From: Thomas Callaway
Sent: 16 May 2014 11:34
To: Planning.Responses
Subject: RE: Planning Consultation on: A/42/14/PL

APPLICATION **A/42/14/PL**

Site Address: Roundstone Farm Littlehampton Road Ferring BN12 6PW

Description of Works: General purpose steel framed agricultural machinery storage building

North Elevation

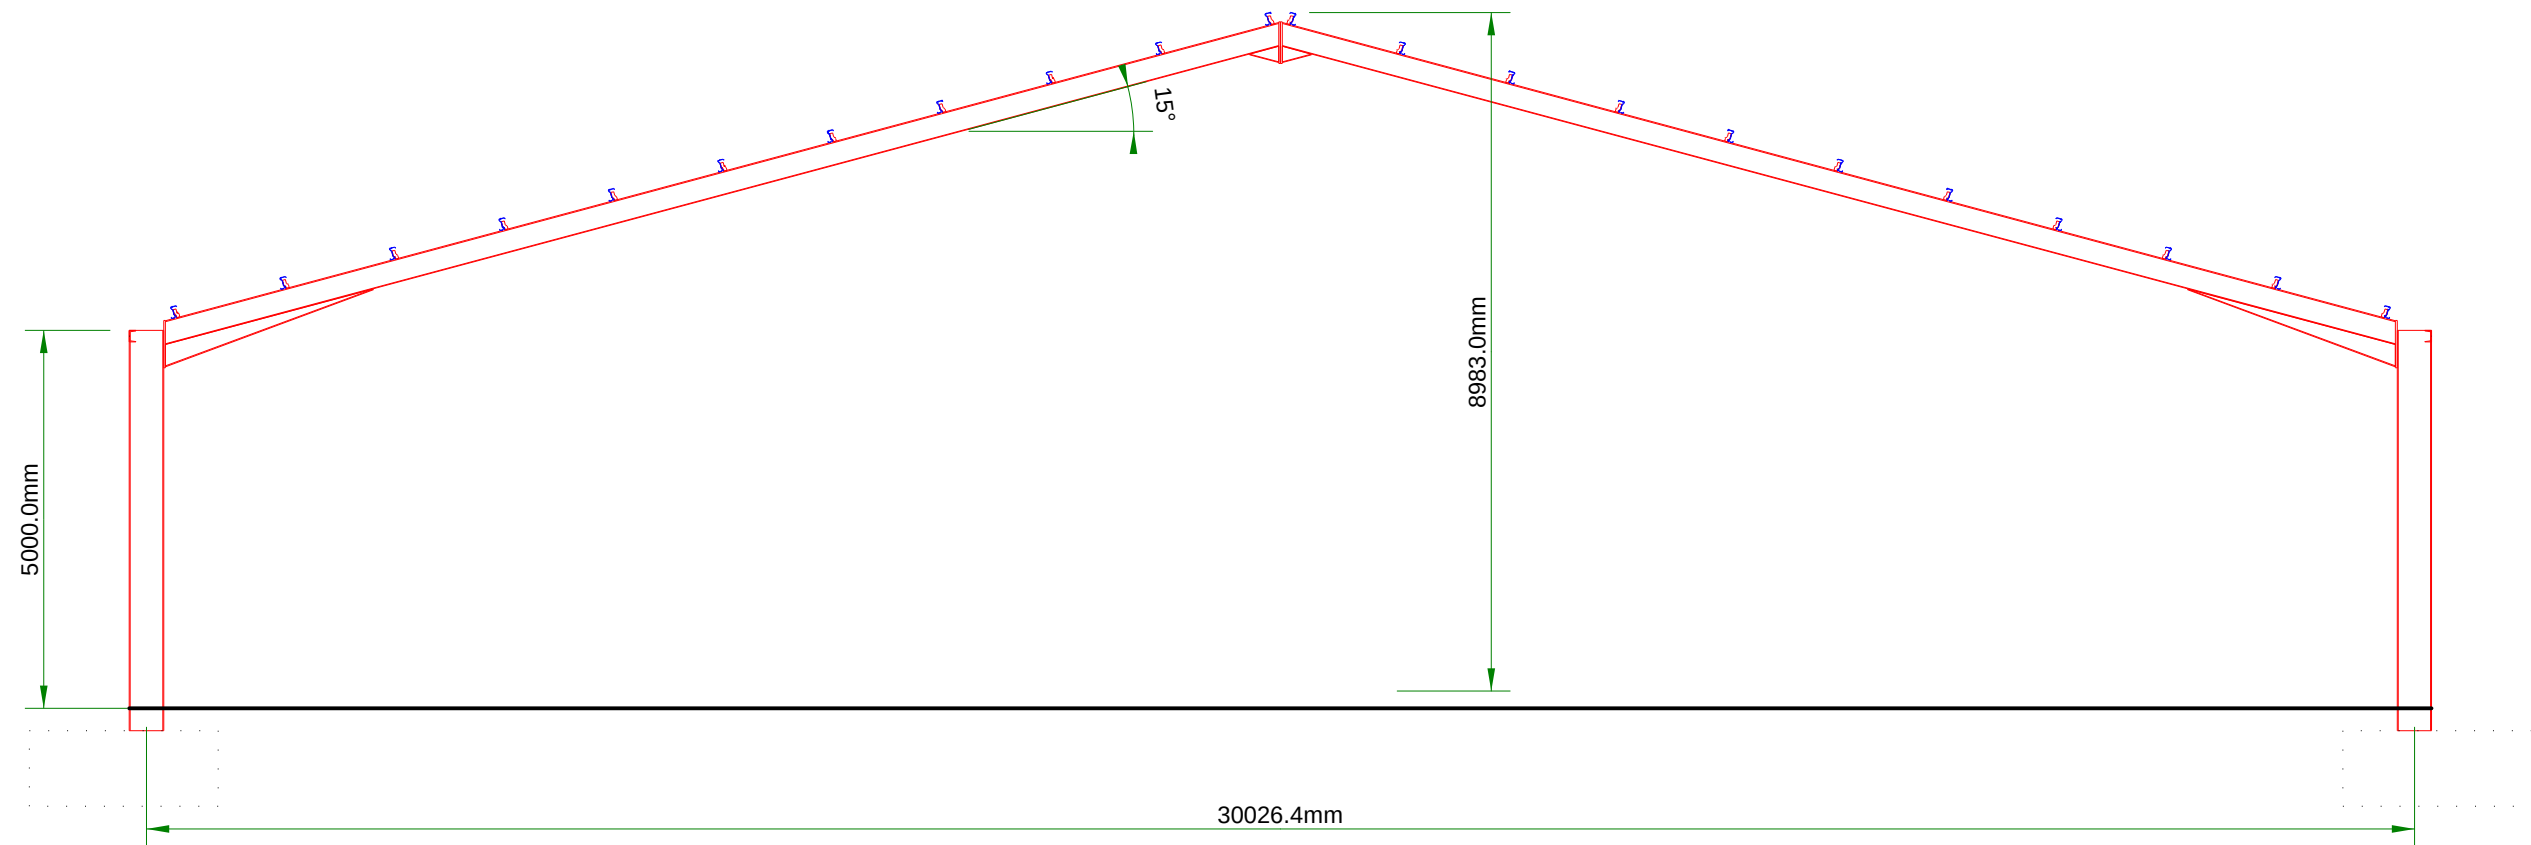
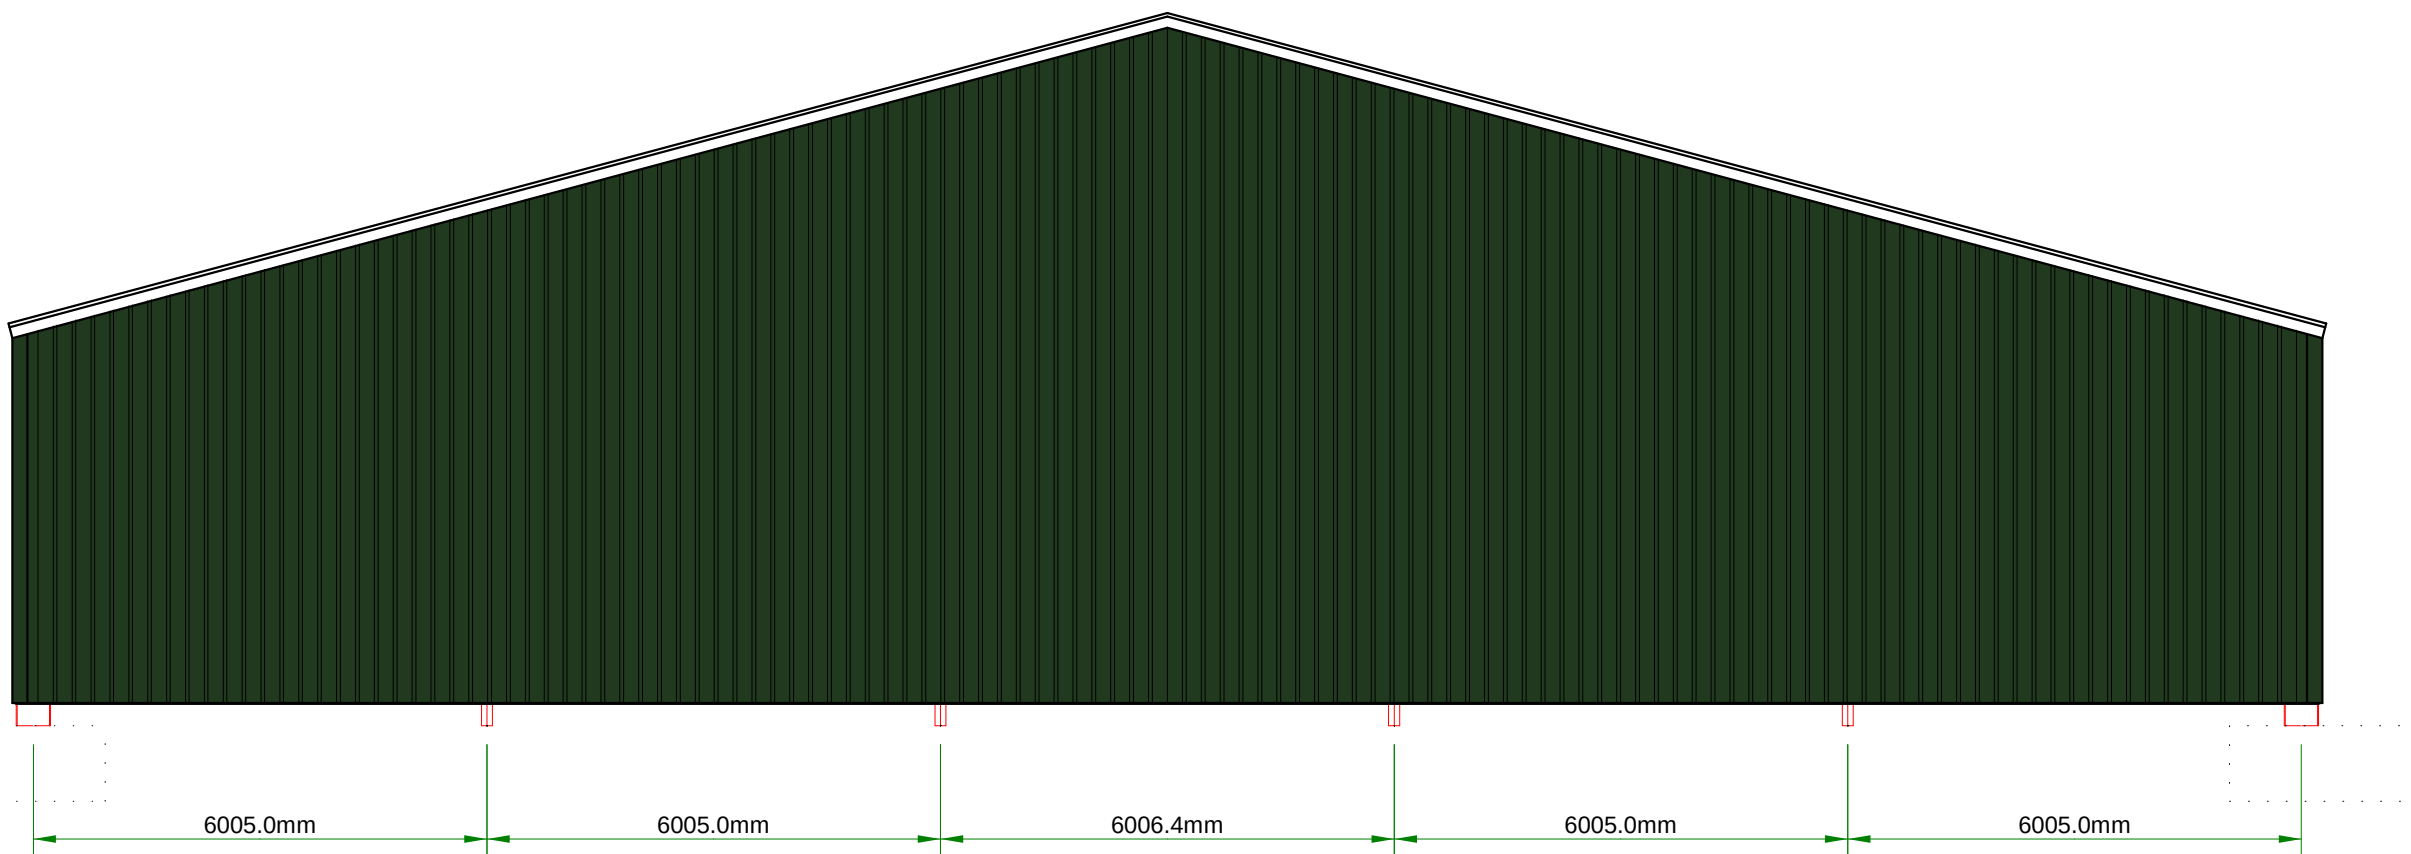
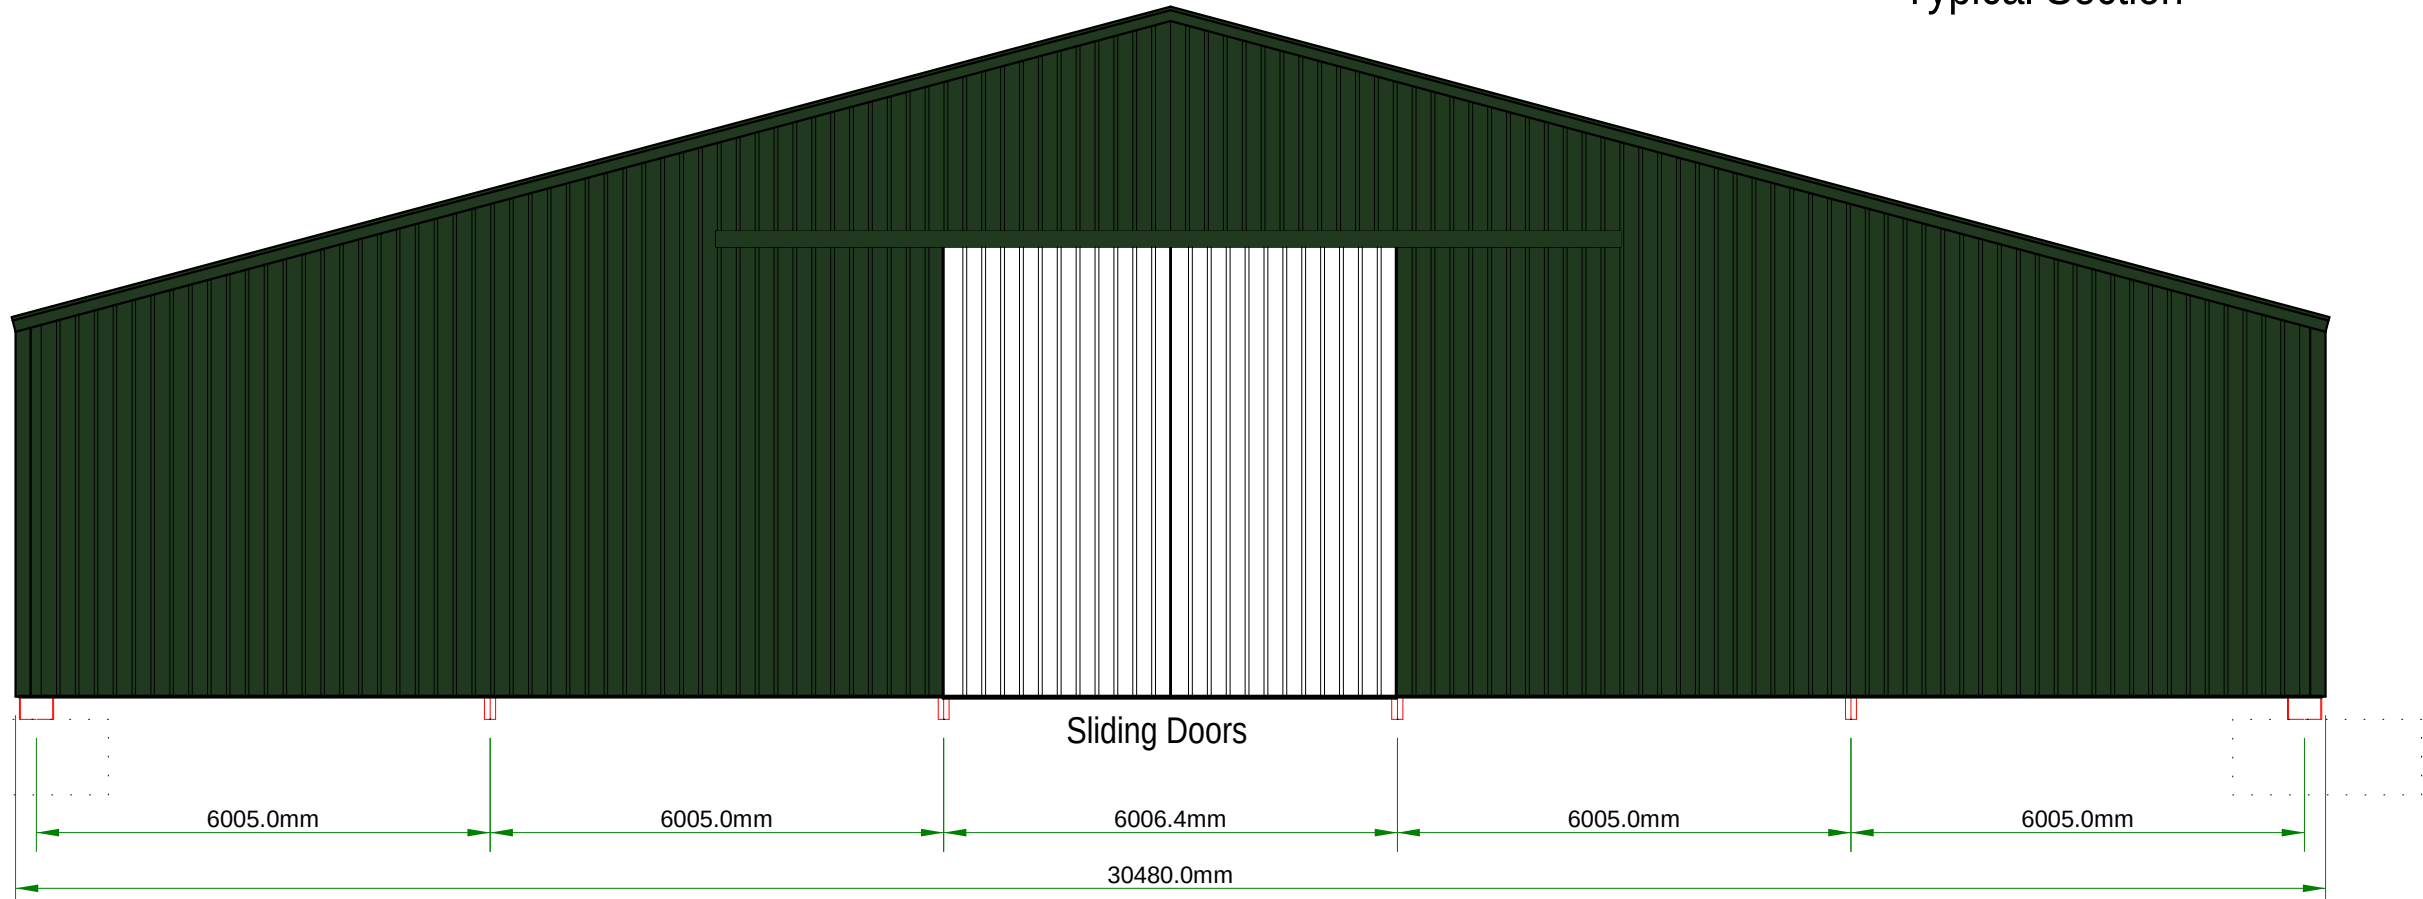
The applicant states that surface water will be discharged to soakaway.

Please apply standard conditions ENGD2A.

Infiltration rates for soakage structures are to be based on percolation tests undertaken in the winter period and at the location and depth of the proposed structures. The percolation tests must be carried out in accordance with BRE 365, CIRIA R156 or a similar approved method and cater for the 1 in 10 year storm between the invert of the entry pipe to the soakaway, and the base of the structure. It must also have provision to ensure that there is capacity in the system to contain below ground level the 1 in 100 year event plus 30% on stored volumes, as an allowance for climate change. Adequate freeboard must be provided between the base of the soakaway structure and the highest recorded annual groundwater level identified in that location.

Any SuDS or soakaway design must include adequate groundwater monitoring data to determine the highest winter groundwater table in support of the design. The applicant is advised to discuss the extent of groundwater monitoring with the Council's Engineers. Supplementary guidance notes are also enclosed for information.
